Your ref: SSD 17352813
File no: MC-21-00001

**SSD 17352813– Huntingwood Processing Facility Expansion – 65
Huntingwood Drive, Huntingwood**

Blacktown Council's submission to SSD 17352813 – Huntingwood Processing Facility Expansion

1. Drainage Engineering Issues

DA4311

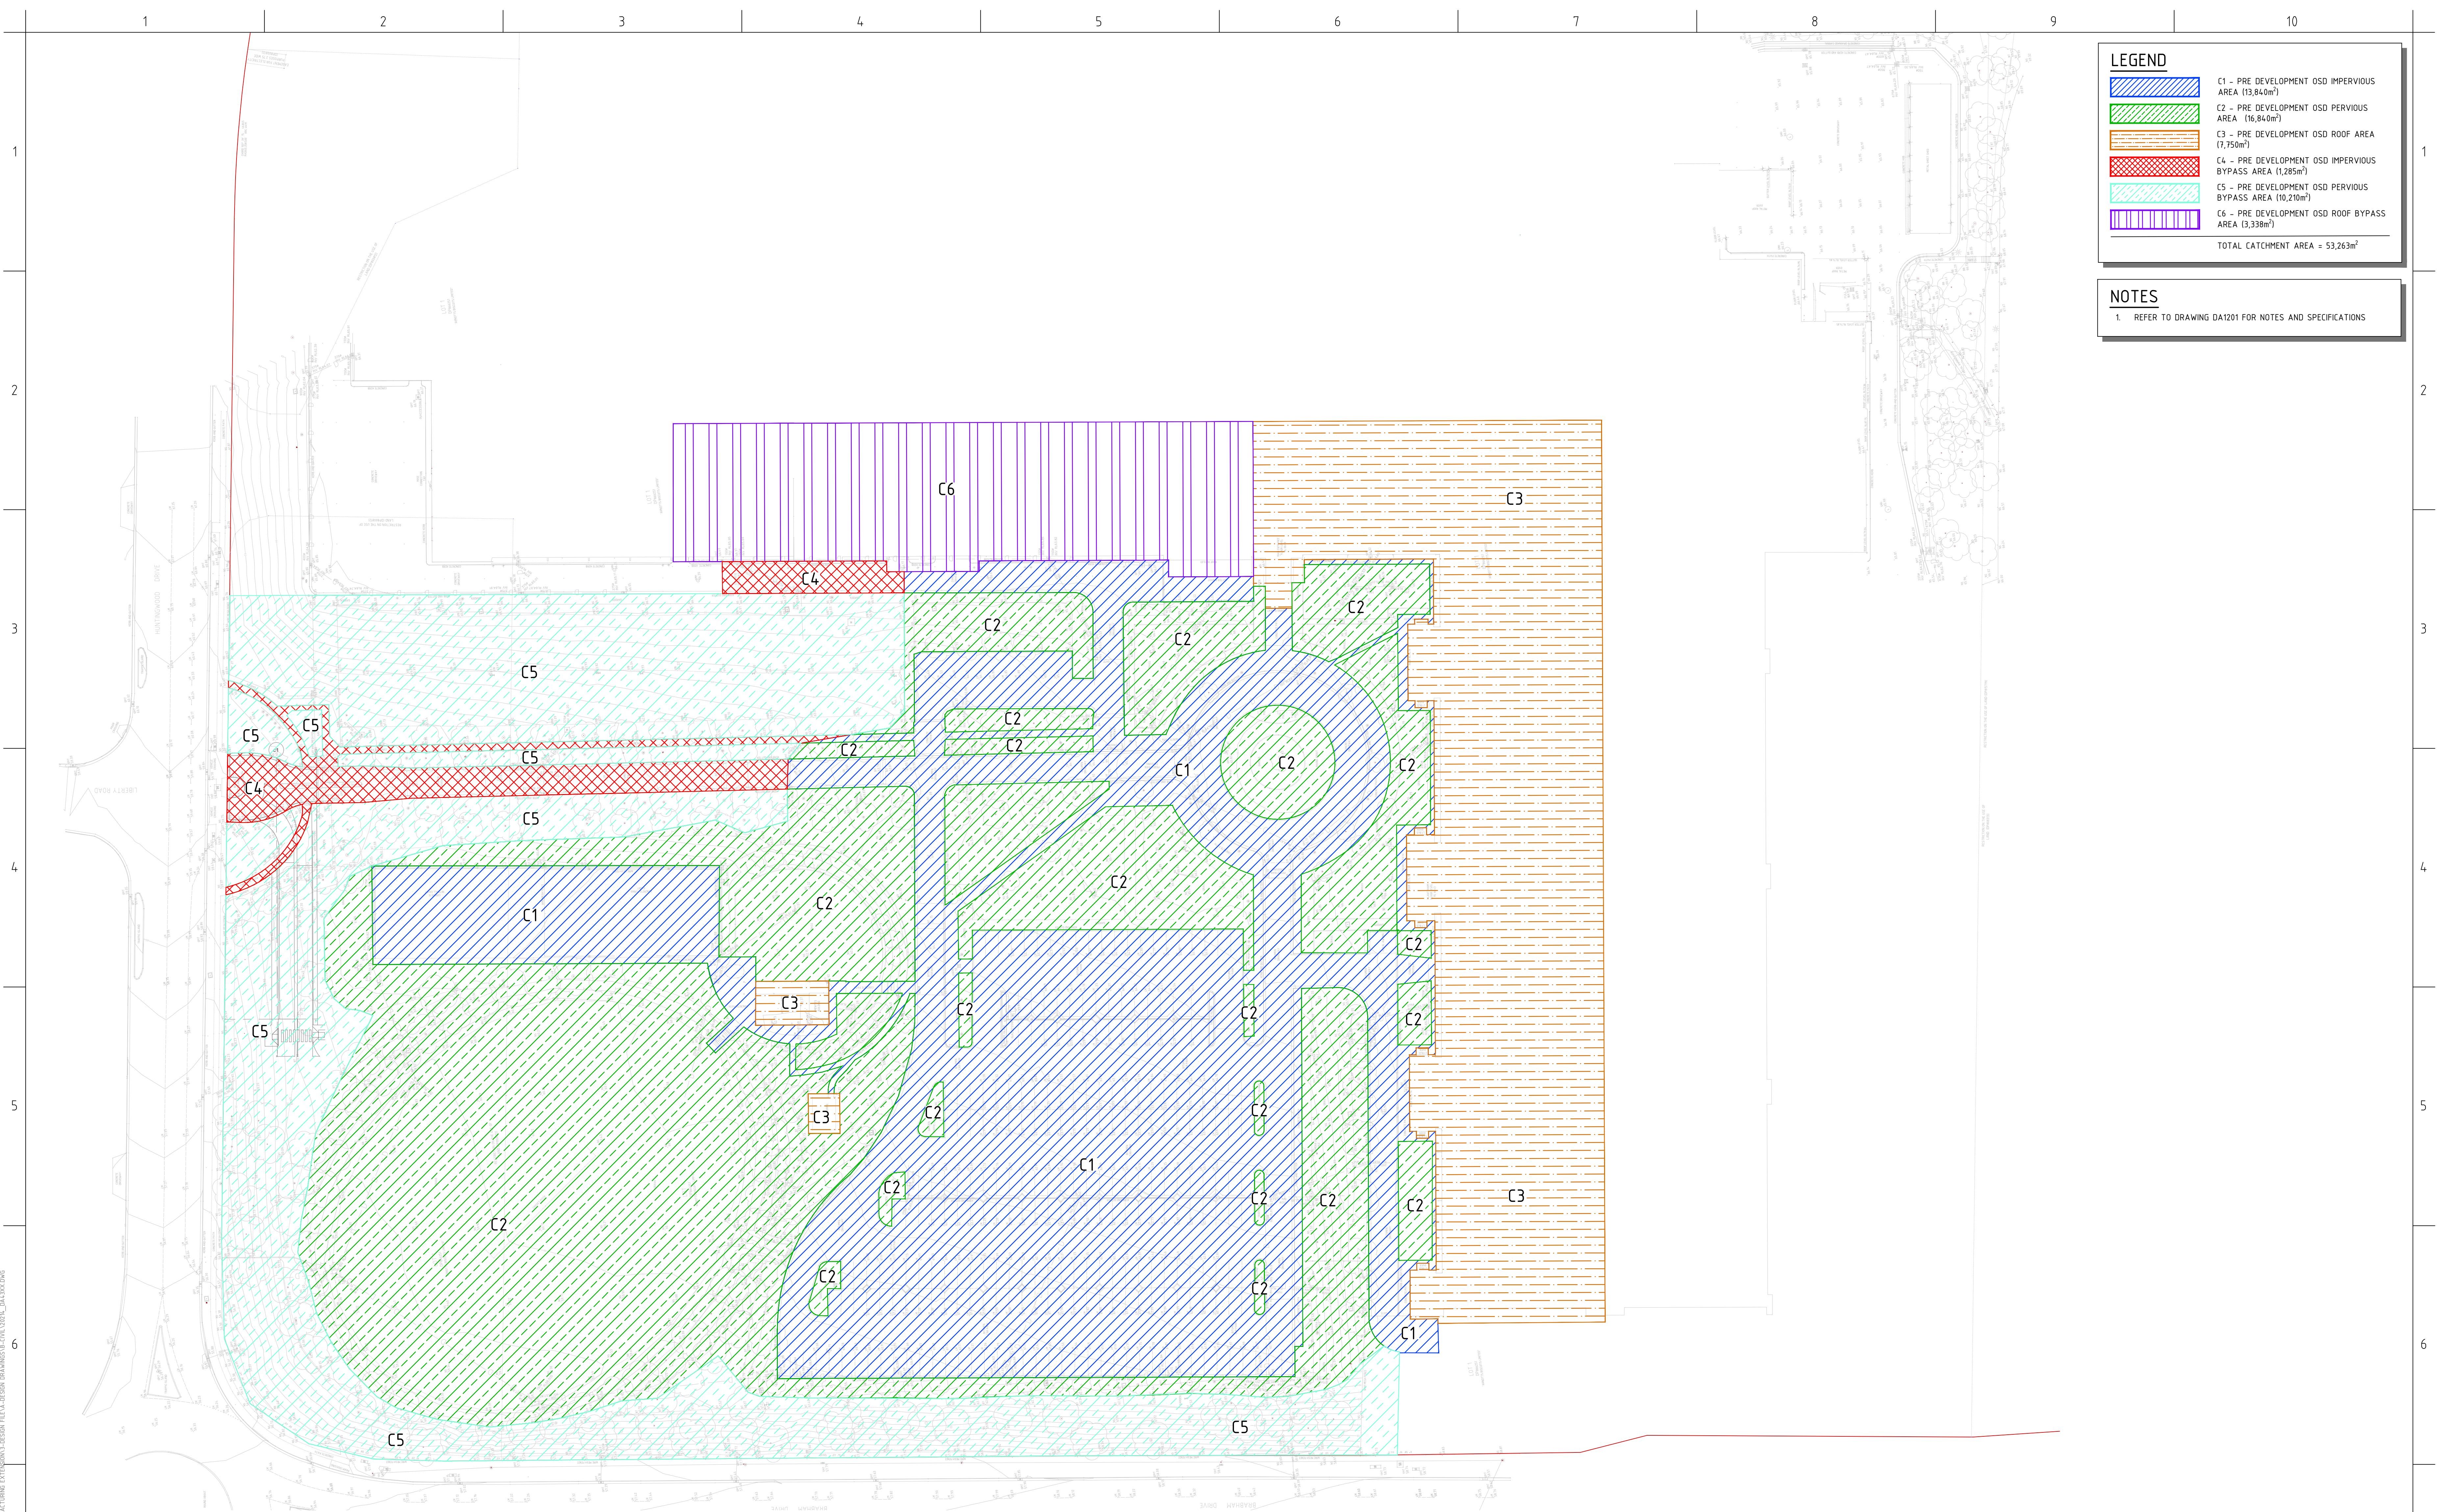
- a. Provide an On-Site Detention catchment plan of the existing On-Site Detention and the proposed On-Site Detention catchment. Considering the existing primary On-Site Detention is to be demolished the pre to post catchment should match. While the areas have been clearly stated in the integrated water report there is no catchment plan associated with this. The report and plans currently do not match and has to be fixed.

- b. The On-Site Detention is to apply to all the development. Any bypass is to be clearly hatched and areas stated. Provide a separate On-Site Detention catchment plan, separate to the water quality catchment plan. Rename plans to suit.
